ALDI ADC

Modification 1

June 2026

This Modification Report has been prepared by Urbis Ltd on behalf of ALDI Foods Pty Ltd (**the Applicant**) pursuant to section 4.55(1A) of the Environmental Planning and Assessment Act 1979 (**EP&A Act**). The application seeks to modify Development Consent SSD-76913969 for the ALDI Automated Distribution Centre (**ADC**) 475 Badgerys Creek Road, Bradfield NSW 2556 (**the site**).

2 NORTH ELEVATION - WAREHOUSE 1 : 600

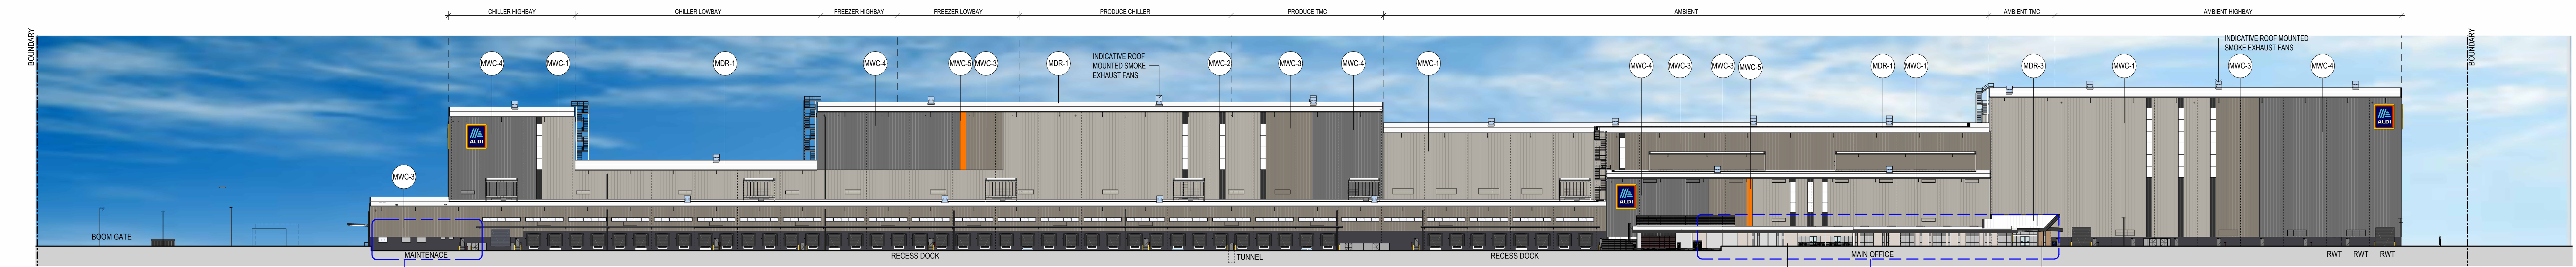
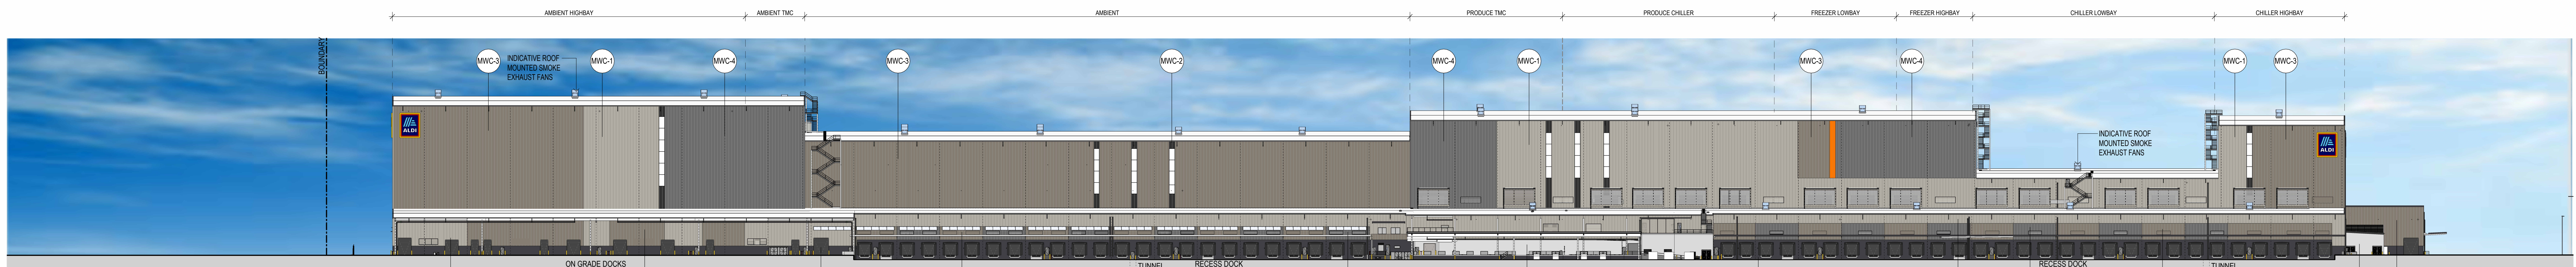
- Addition of louvres to façade location at lower levels to facilitate make-up air for smoke exhaust purposes.

Addition of louvres to the facades walls to facilitate mechanical make-up air for smoke exhaust, incorporated as a result of the detailed design development..
